Our Ref: BR/10/17/PL
Your Ref:

Town & Country Planning Act 1990 (as amended)
Town and Country Planning (Development Management Procedure) (England) Order 2015
Application for Planning Permission

Development Change of use to create additional A1 and B8 floorspace and removal of B2 floorspace, single storey side extension, alterations to windows, installation of palisade gates, installation of roller shutter, alterations to parking layout and installation of external security lighting

Location Site B Durban Road Bognor Regis

Ground Floor Plan (Proposed)

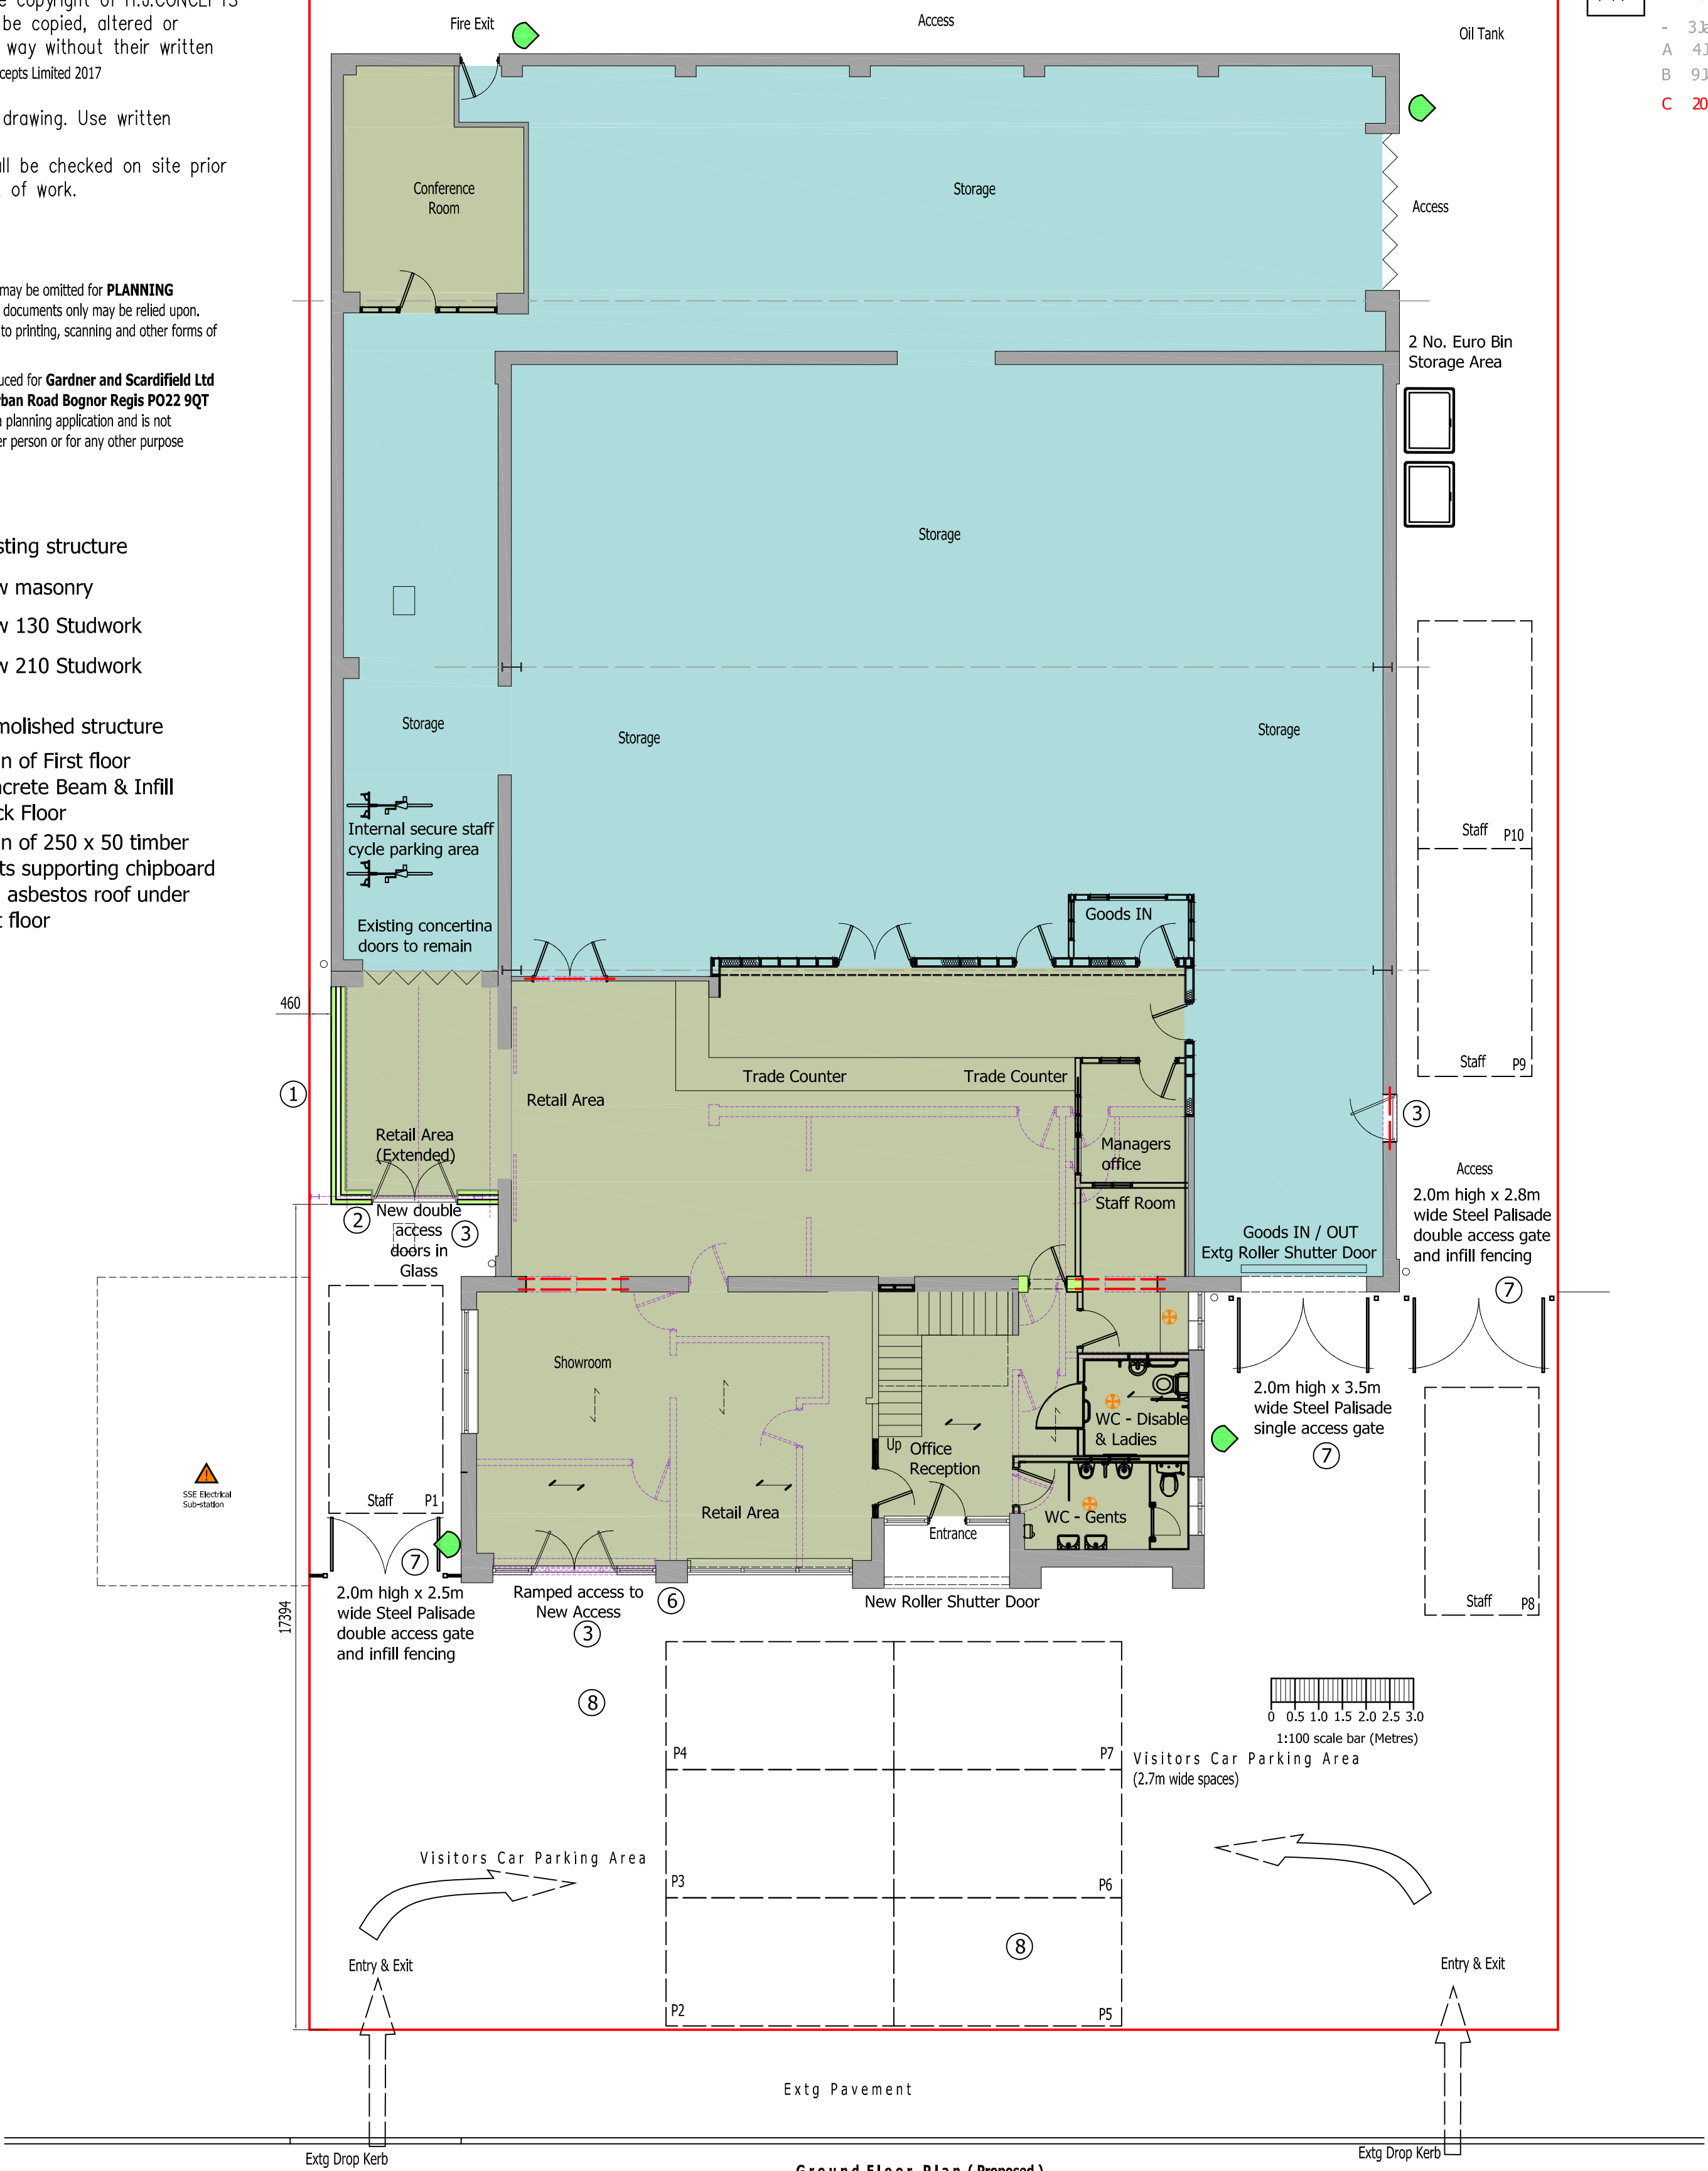
The description refers to security lighting but they have not been shown on the plans;

Please add the dimensions to demonstrate the distance between the extension and the boundary lines on the block or floor plans.
